The SCOPING OPINION:

Proposed Teesside Flexible Regas Port

Case Reference: EN040001

22 April 2024

Figure 7.2b
Statutory designated sites within 2km

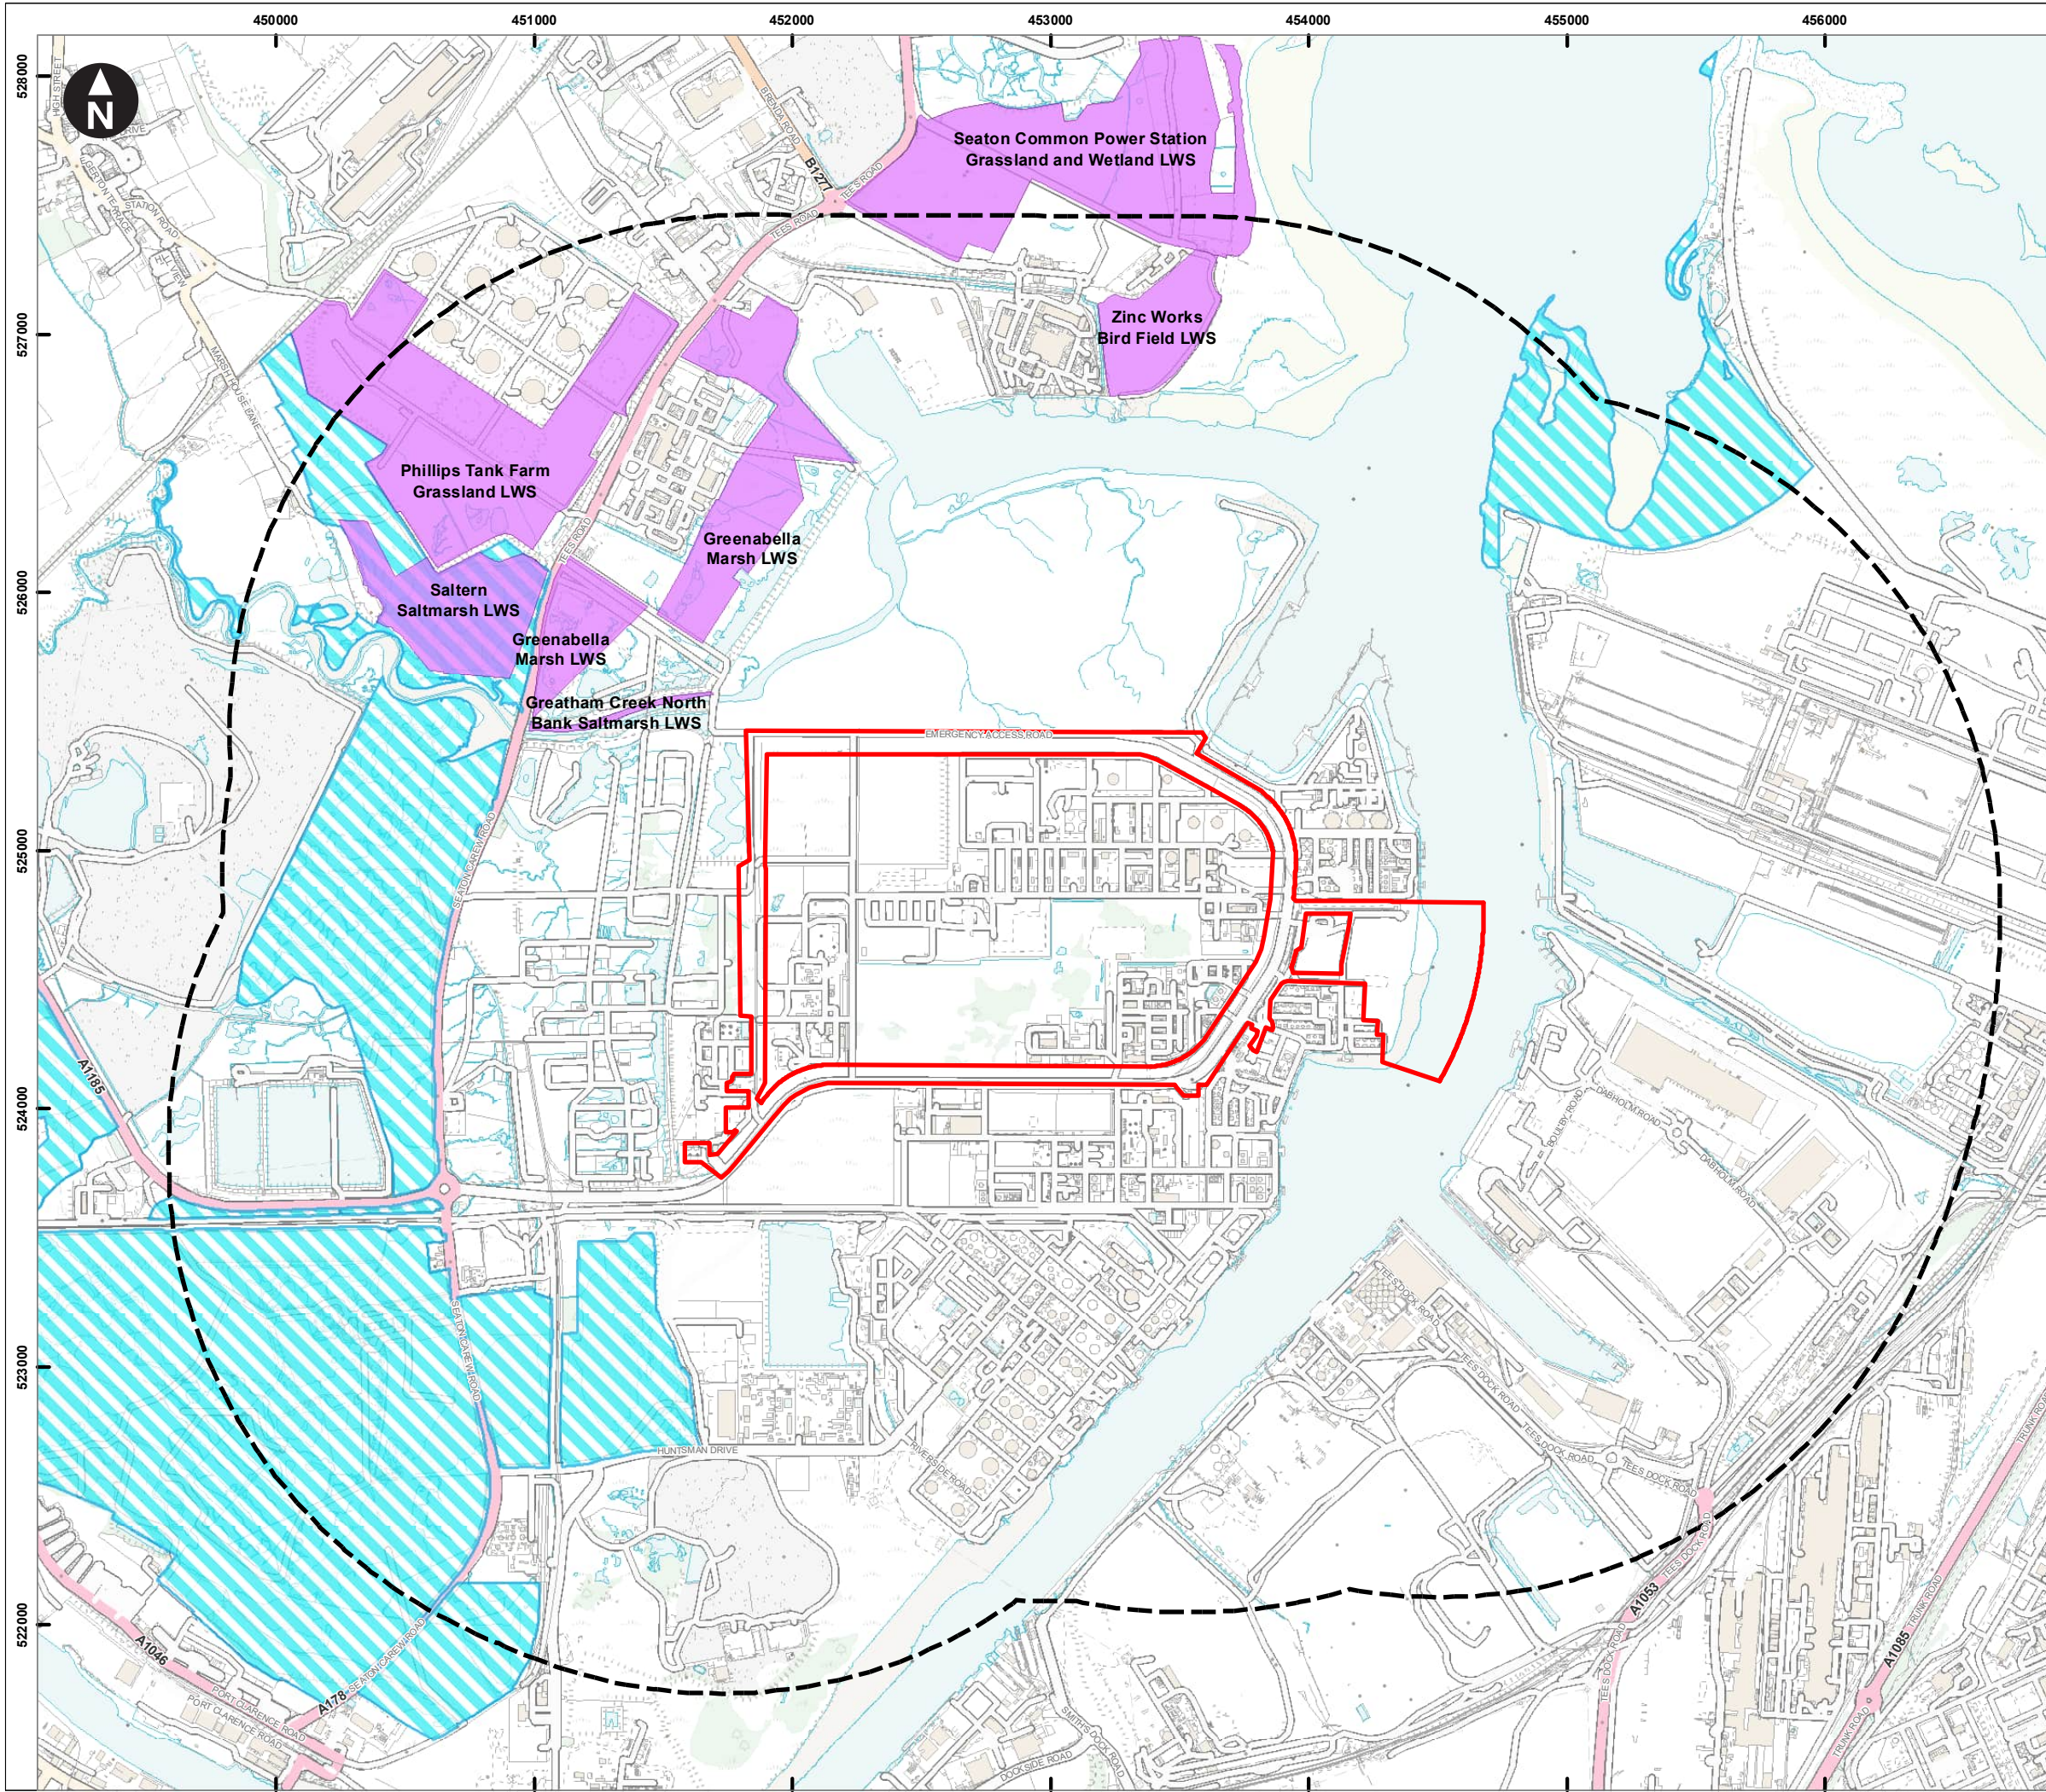
ID	Ref	Applicant's proposed matters to scope out	Inspectorate's comments
3.3.15	Figure 7.2b	Labelling of designated sites	Figure 7.2b shows SPAs, SSSIs, NNRs and LNRs, however the various layering makes it difficult to interpret, for instance, there are two areas of SSSI which are not labelled, one is directly adjacent the red line boundary. Although it is assumed this is part of the Teesmouth and Cleveland SSSI, the Inspectorate suggests that additional labelling is used in figures in the ES to clarify sites and enable legibility.

Figure 7.3
Non-statutory designated sites

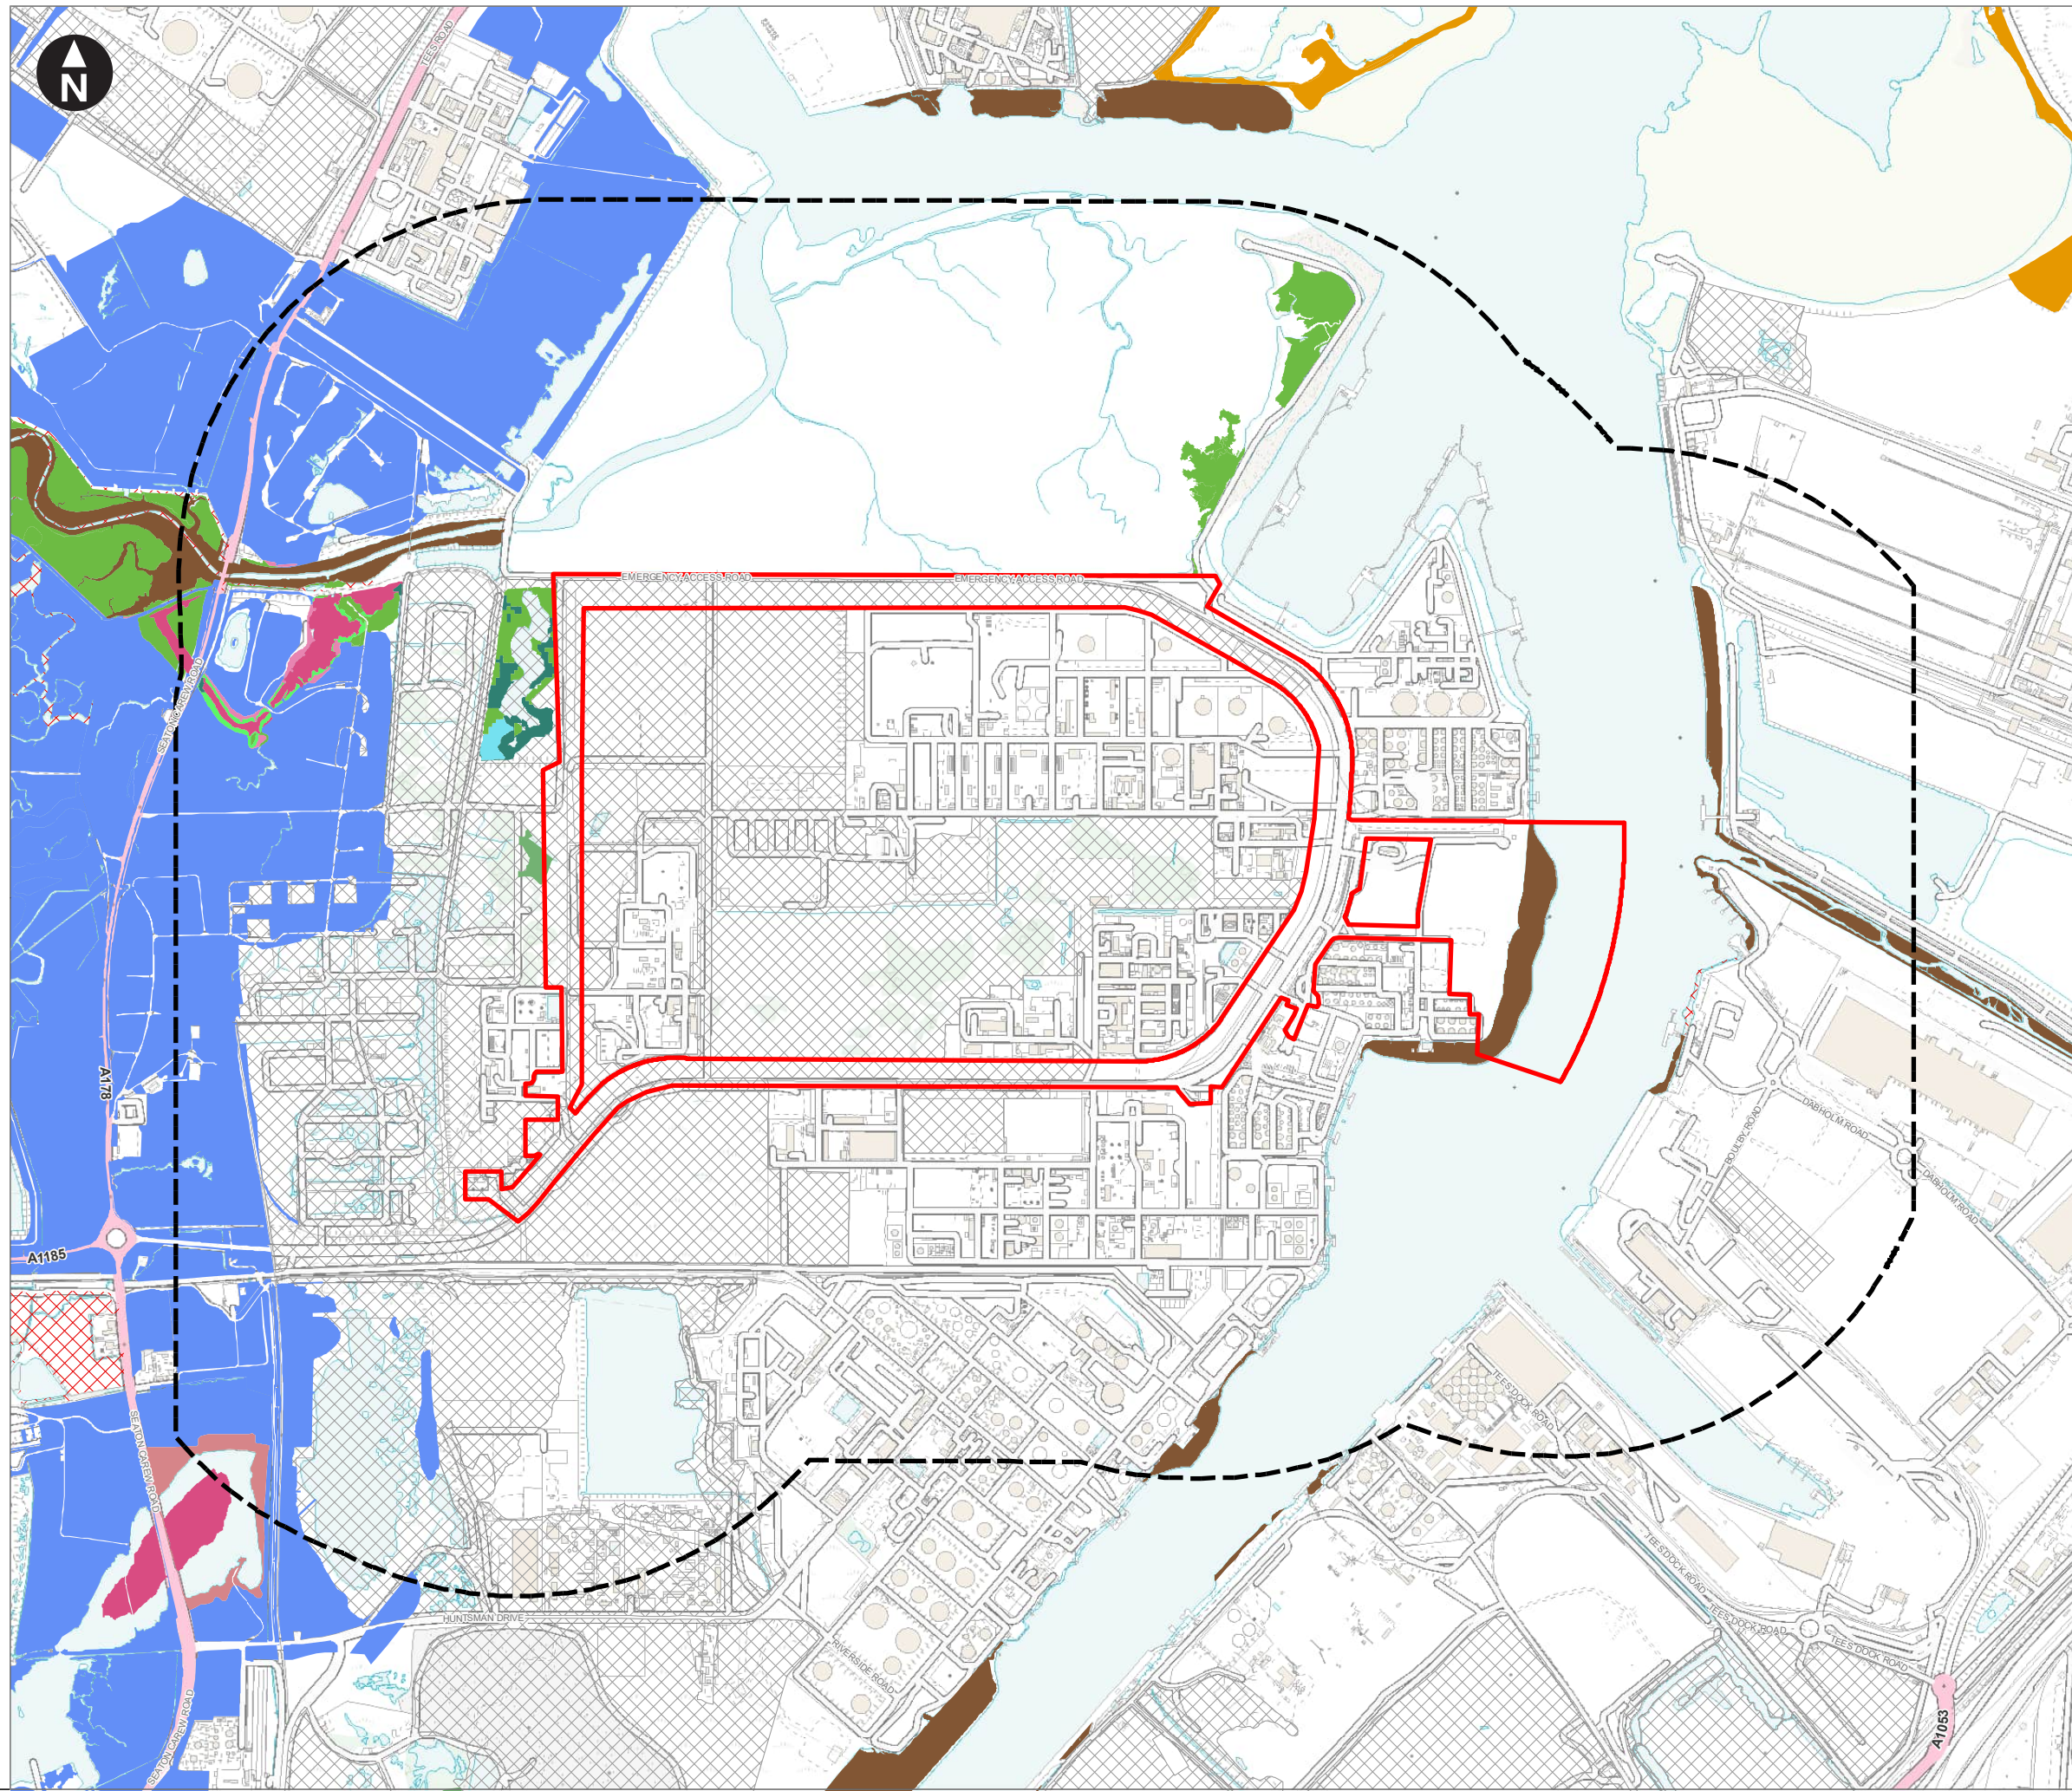
ID	Ref	Description	Inspectorate's comments
	and Figure 7.3		Proposed Development, but not all the sites shown on Figure 7.2a are listed in paragraph 5.6.1. Likewise, Figure 7.3 shows non statutory designated sites which are not listed in paragraph 5.6.1. The ES should present a justification for any ecological sites within the study area that are excluded from the assessment based on relevant guidance. This should be done in consultation with the relevant consultation bodies.
3.1.6	N/A	Study area and location of sensitive receptors	The air quality figure provided within the Scoping Report (Figure 5.1) shows the location of monitoring locations. The ES should also contain a figure to identify the study area used for the air quality assessment, which includes the sensitive receptors identified for the assessment.
